Your Ref :
Our Ref : LU/233/14/NMA

Section 96A of the Town & Country Planning Act 1990 (as amended)
Town and Country Planning (Development Management Procedure) (England) Order 2010 (as amended) - Article 9

Application for a non-material amendment following planning permission LU/115/14/HH - relating to enlarging the raised decking area
36 Clun Road, Littlehampton, ,

DRAWING NO:	REVISION:
1043/1	A

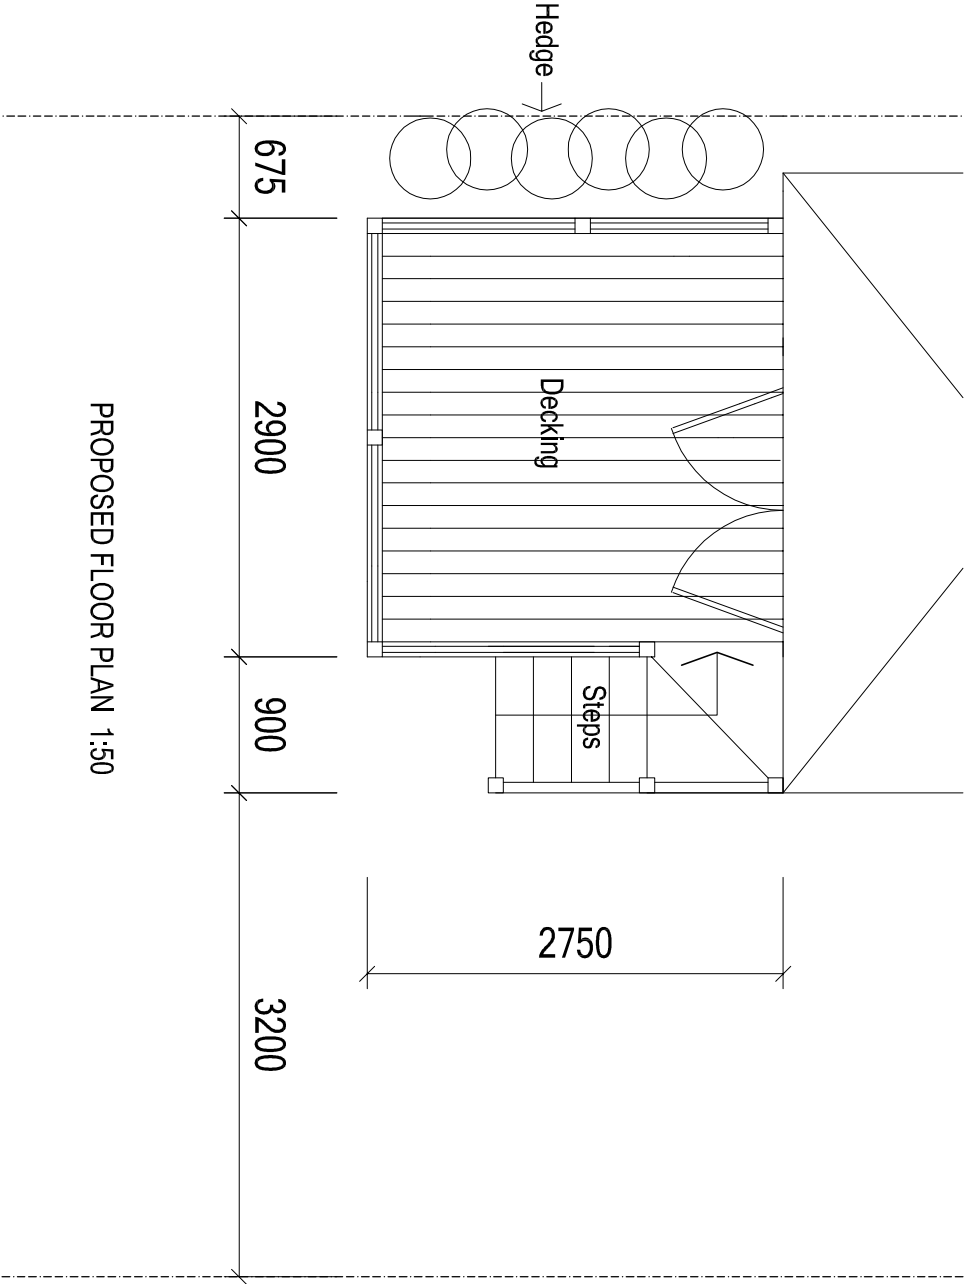
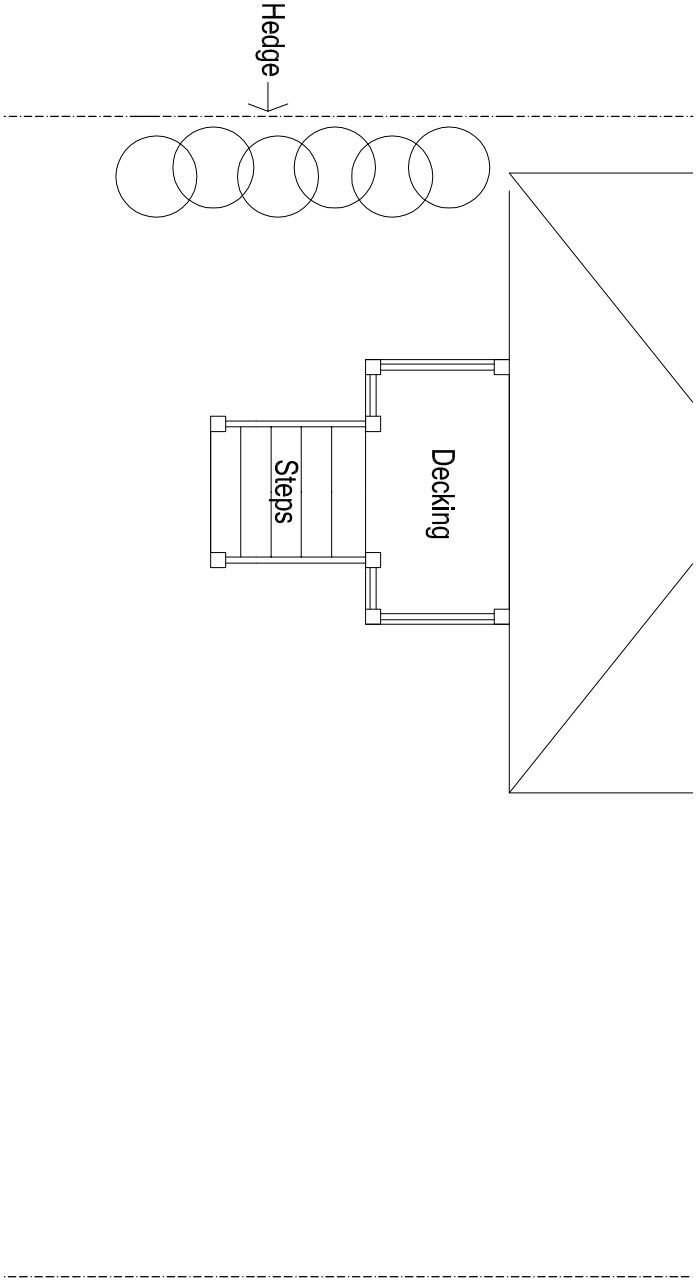
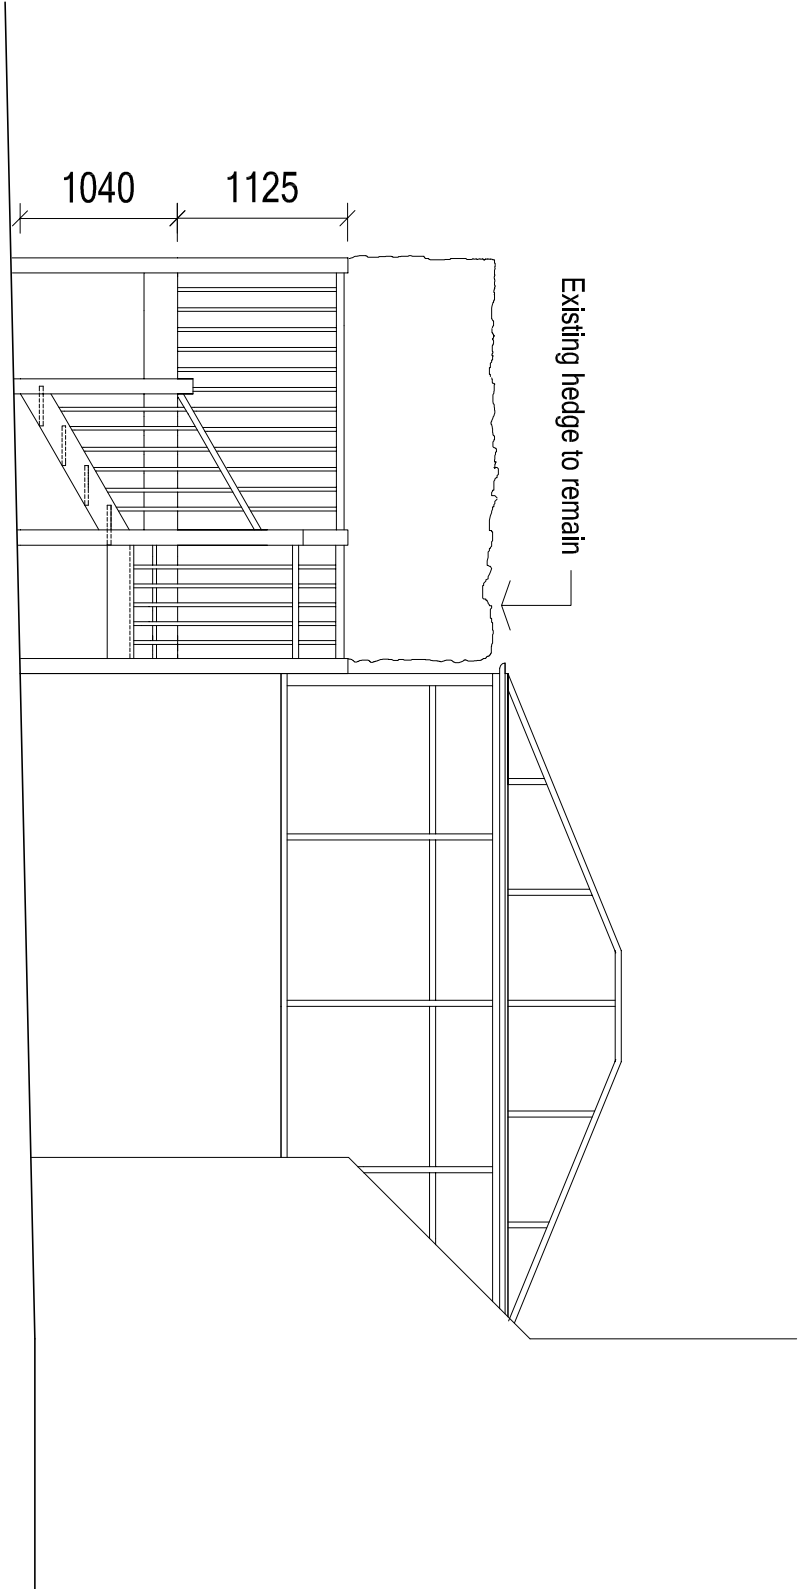
I refer to your recent application for a Non Material Minor Amendment. From the information submitted I am able to take the increase in size of the raised decking area by 0.3m depth and 0.5m width and the altered position of the access from the east side of the decking area to the west west side as a Non Material Amendment to LU/115/14/HH.

Accordingly drawing nos 1043/2 revA dated 10-09-2014 and 1043/1 revA dated 10-09-2014 have become the approved plans for LU/115/14/HH.
